Ms Claire Muir  
Town Planning Advisor  
1 Reserve Road  
St Leonards NSW 2065

24/06/2021

**UNSW Health Translation Hub (SSD-10822510)**  
**Response to submissions**

drawing
Shadow Analysis

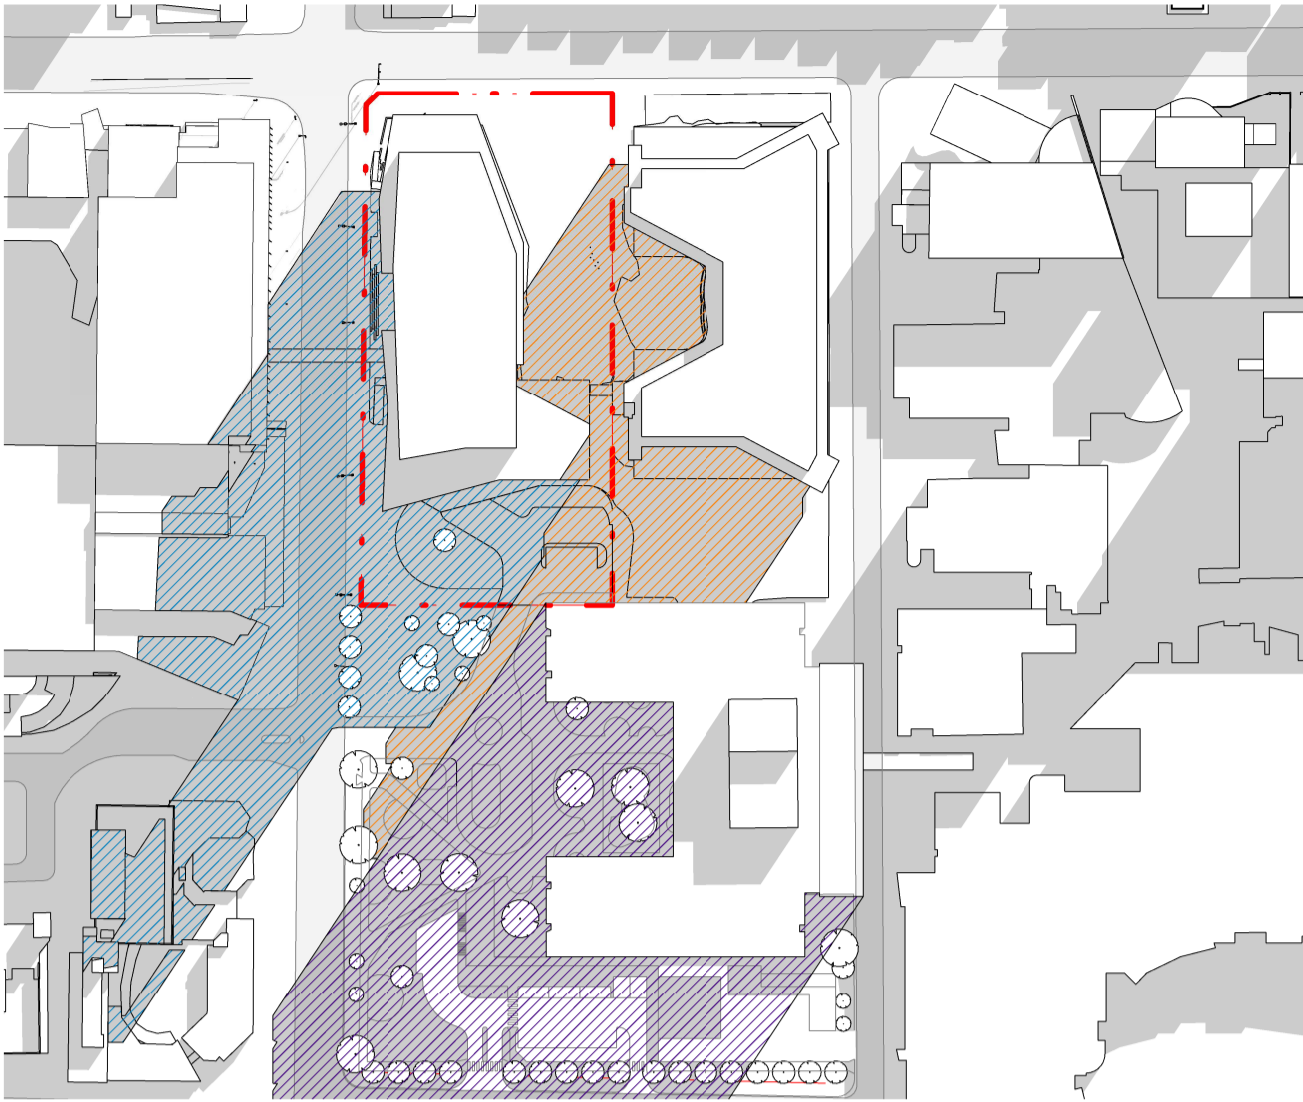
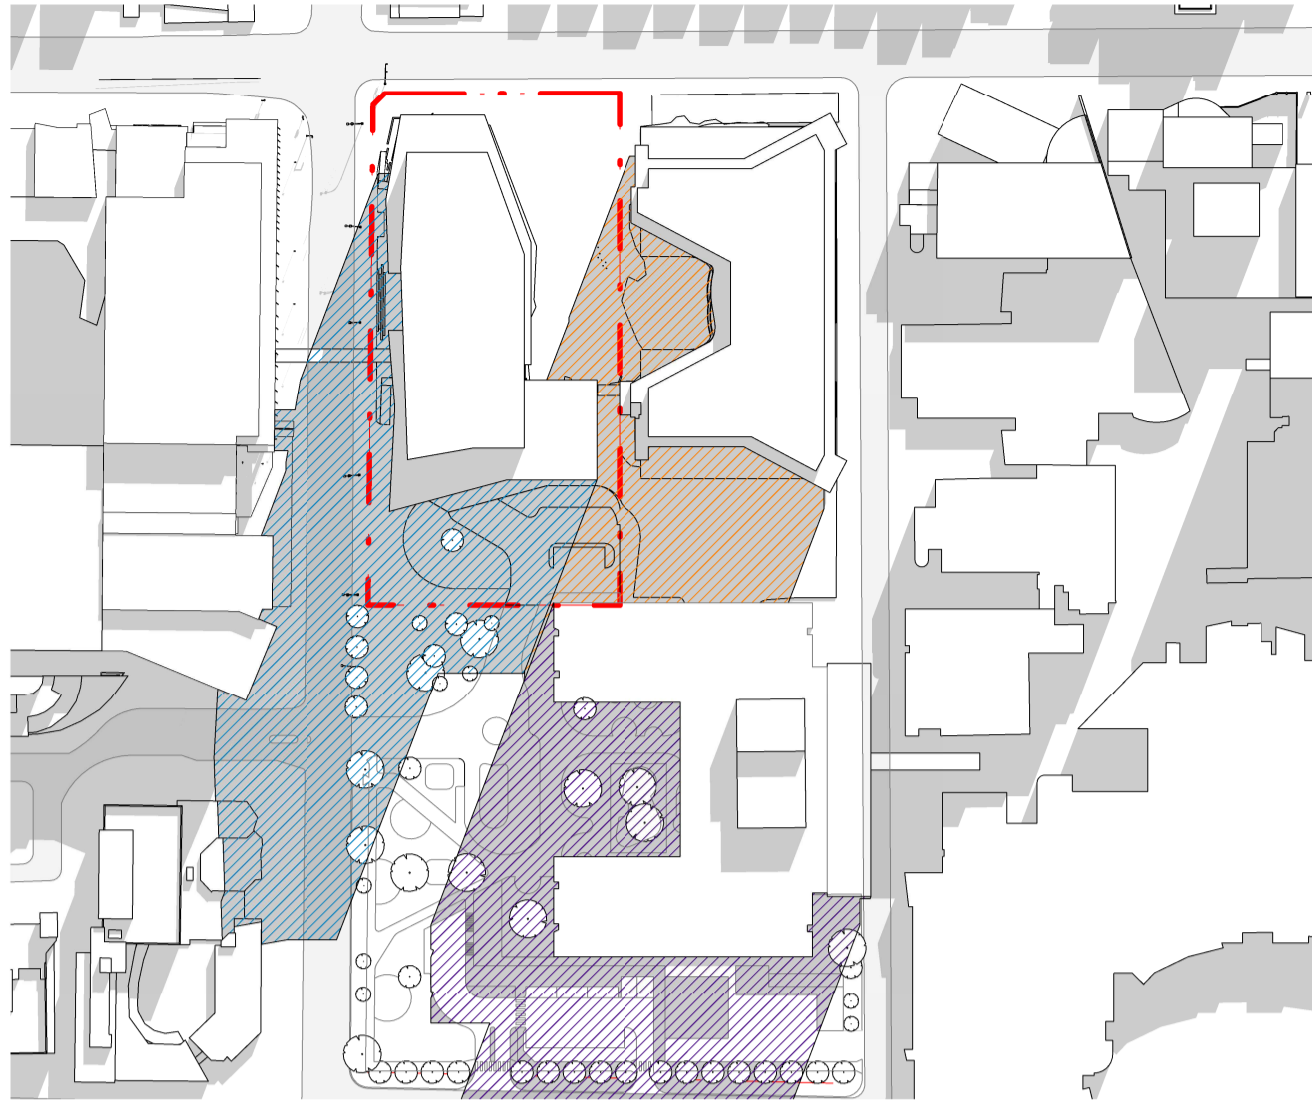
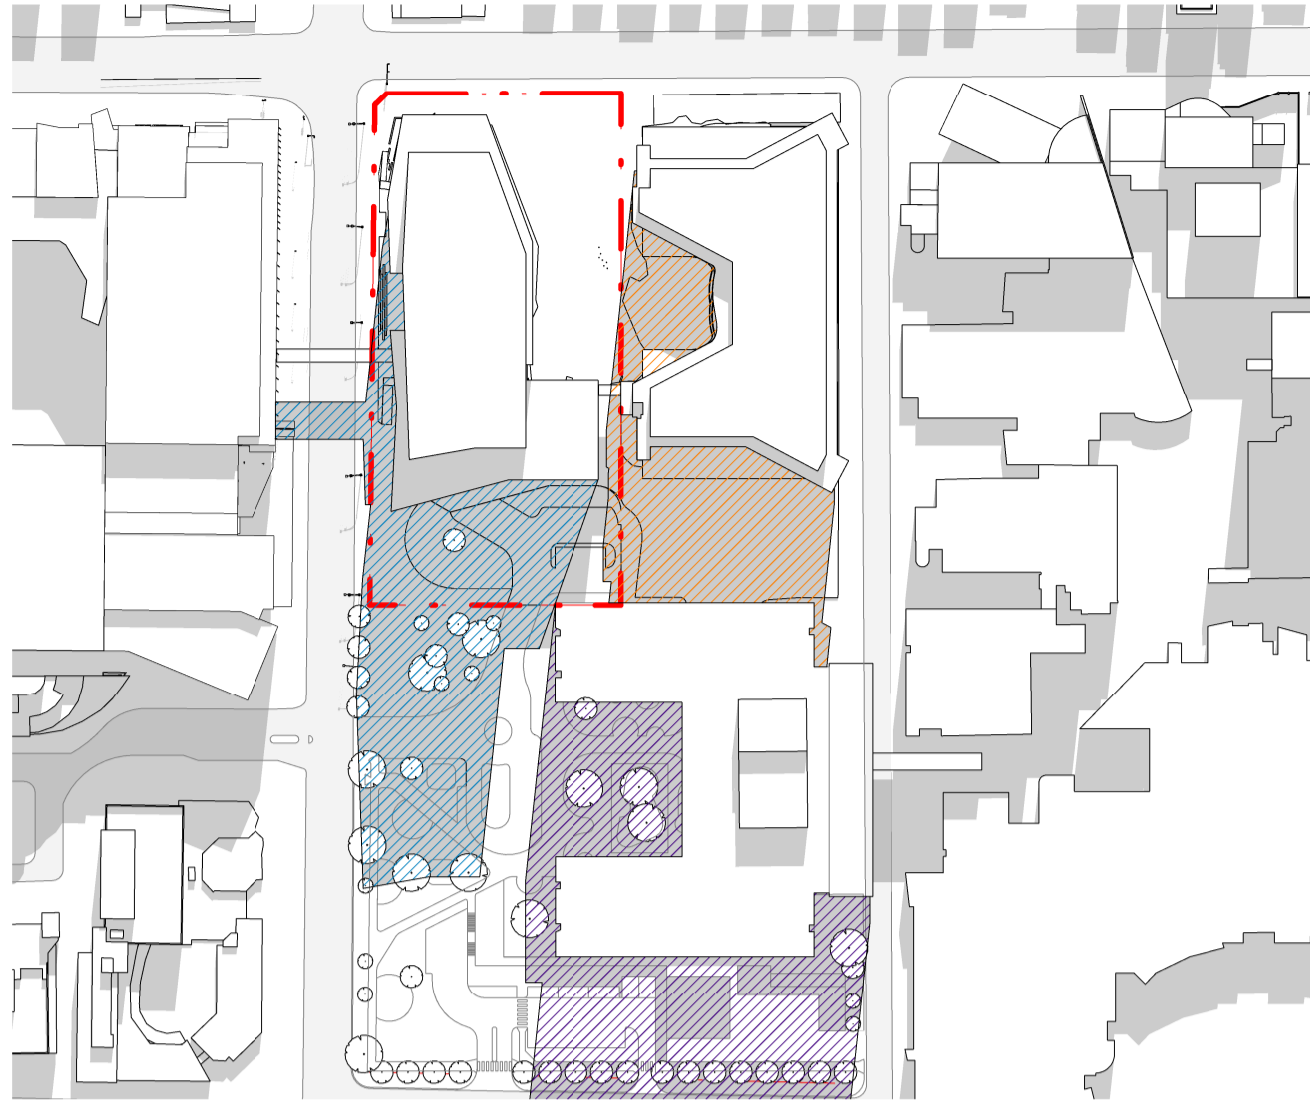
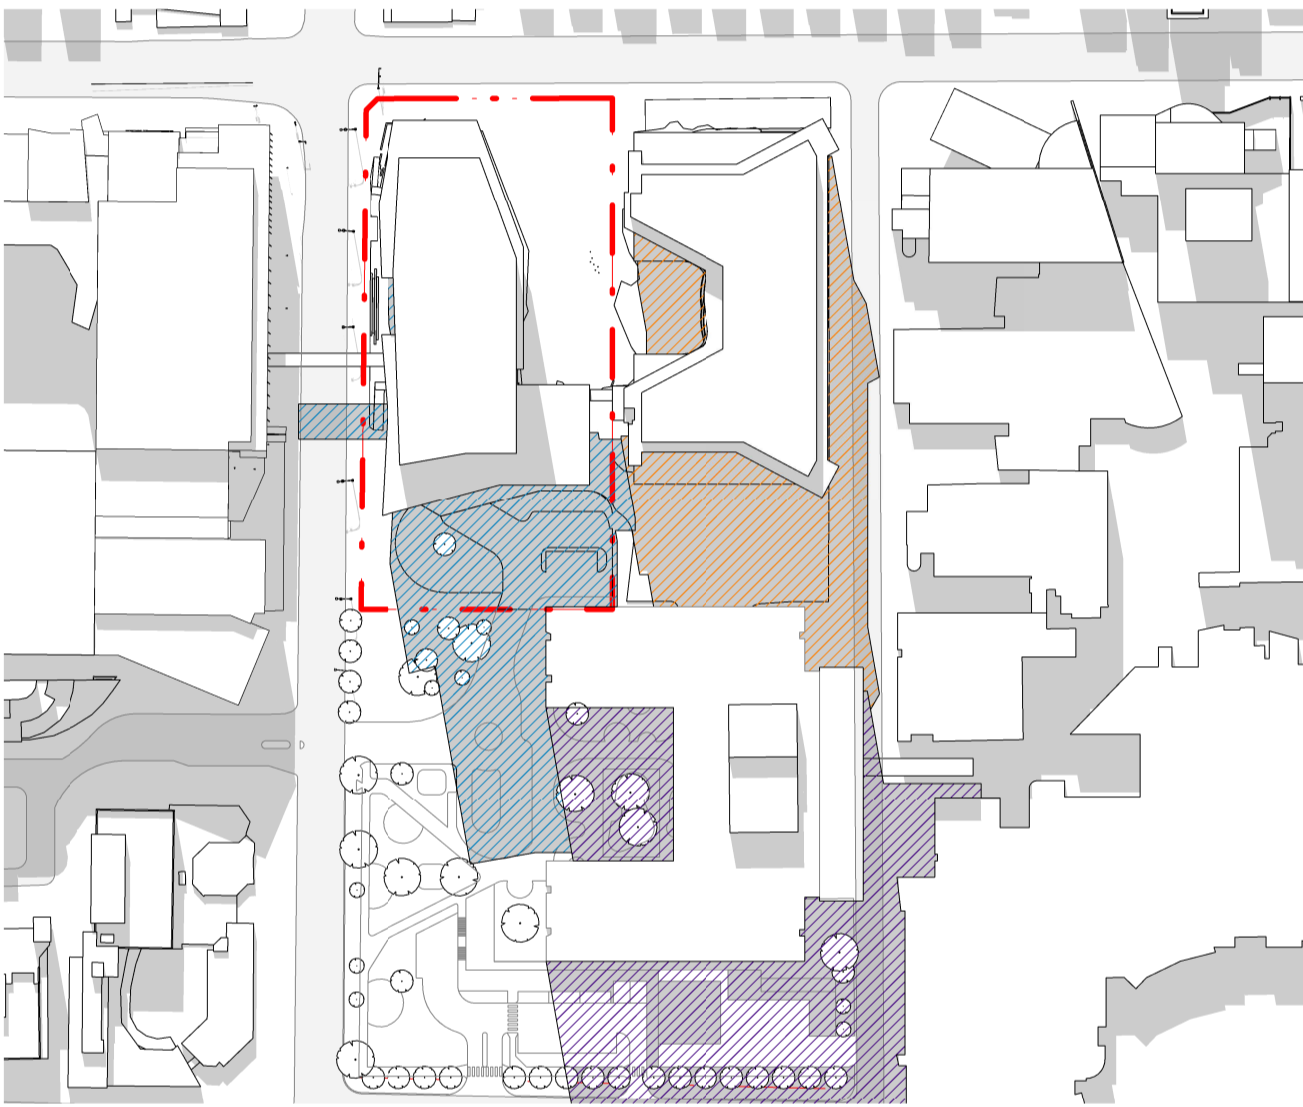
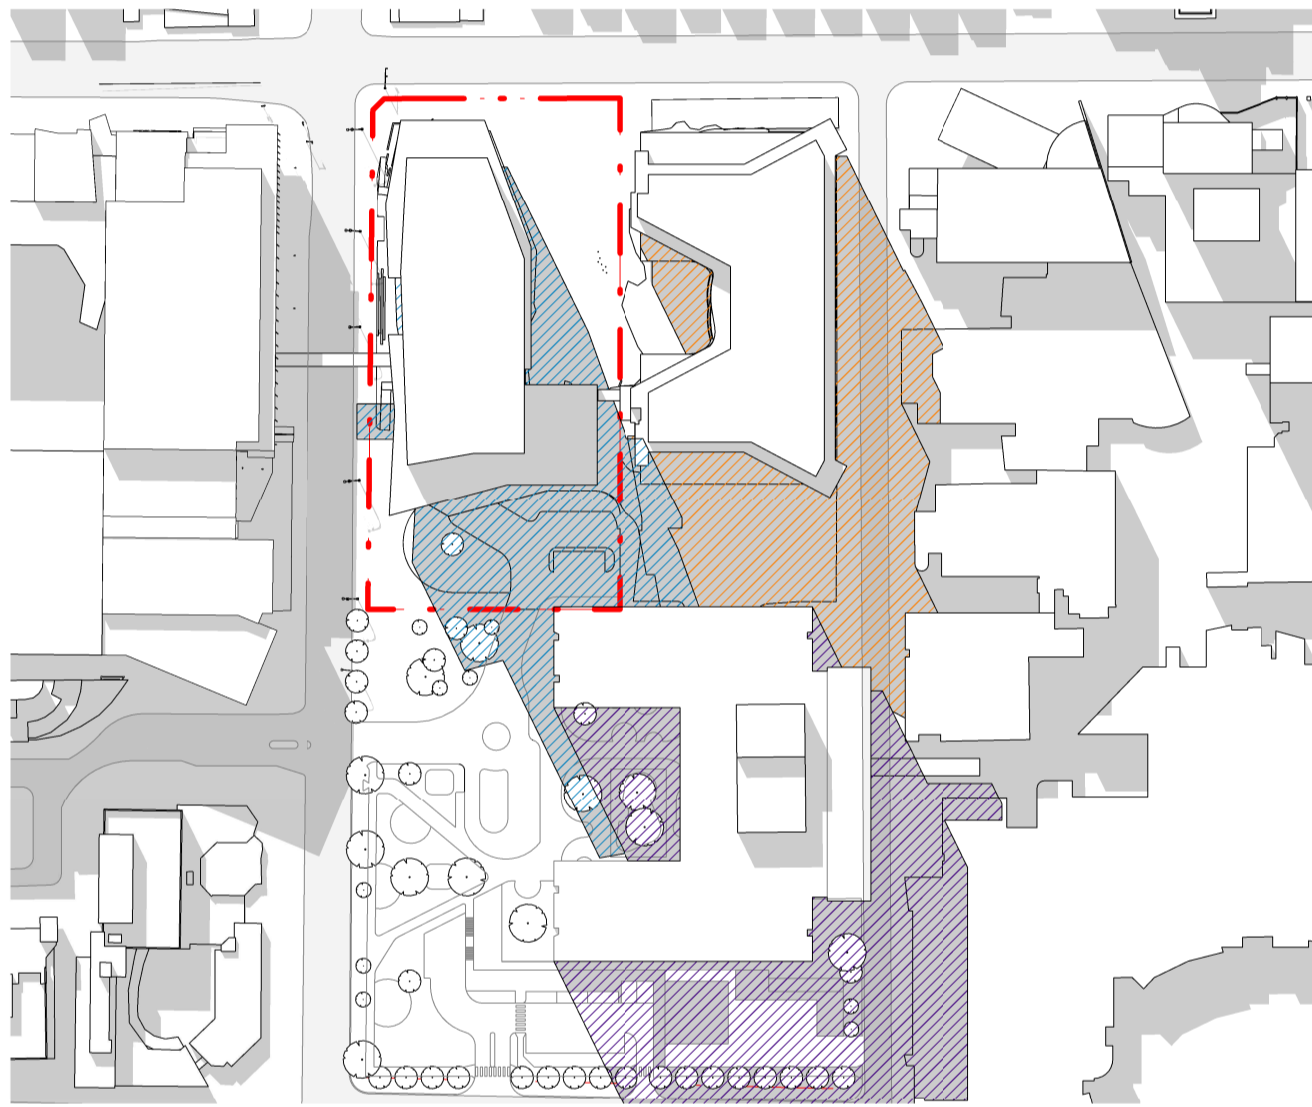
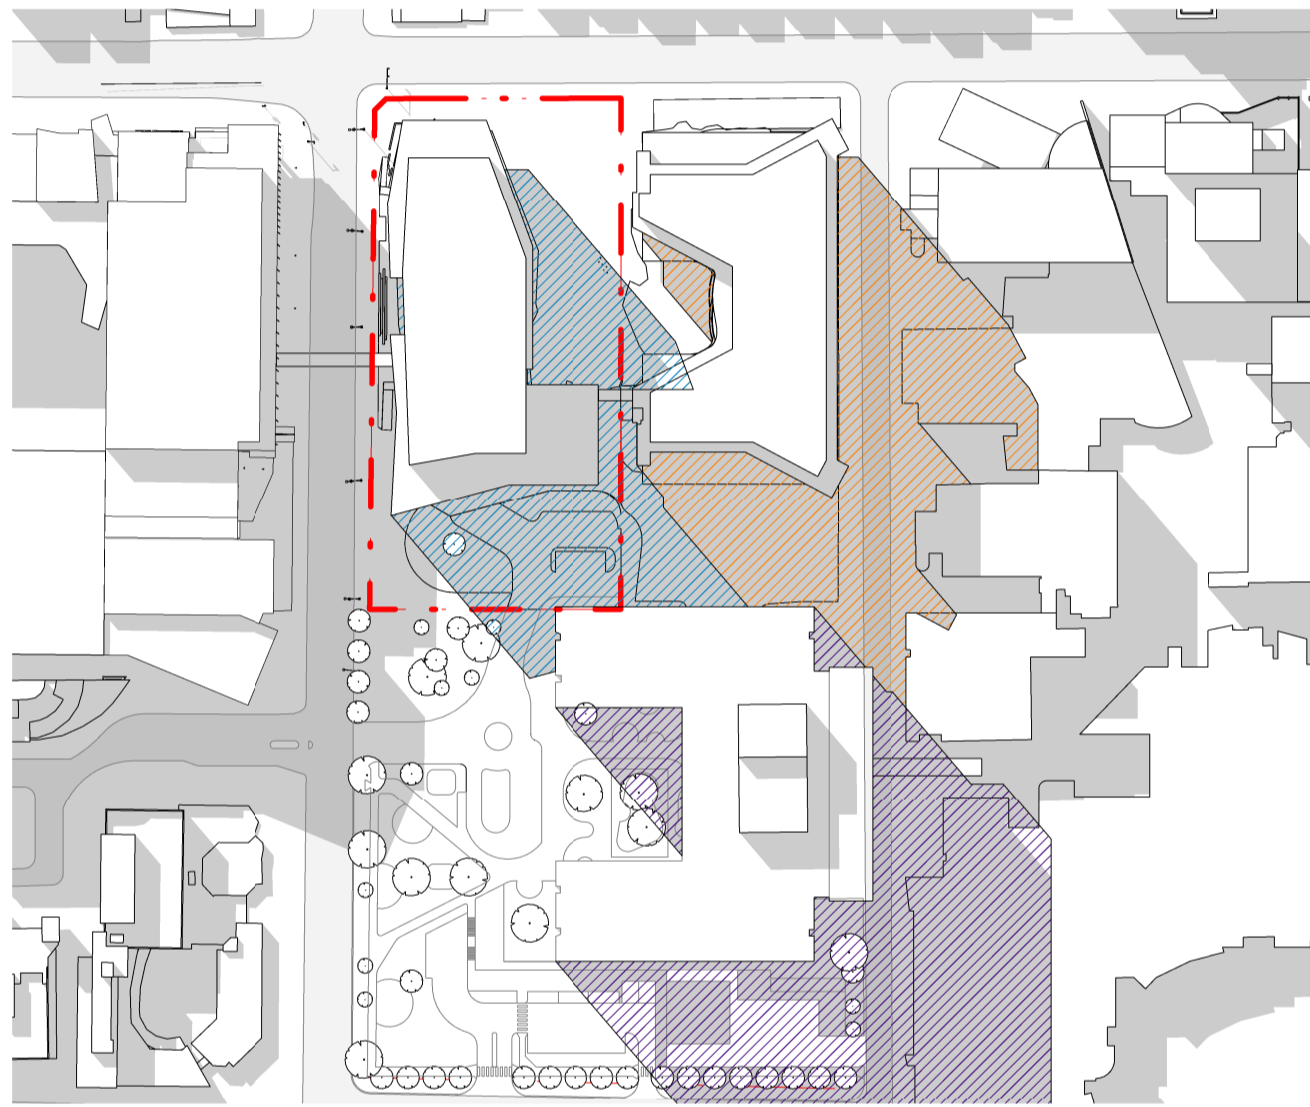
- Consideration should be given to improving tree canopy cover, noting the proposed 14 per cent coverage falls short of minimum 25 per cent recommended within the NSW Government Architect’s Draft Greener Places Design Guide. Any comparisons against the ‘existing’ canopy coverage to justify the proposed canopy cover should be based on an assessment of the canopy cover of the previous residential use of the site, prior to clearing of the site.
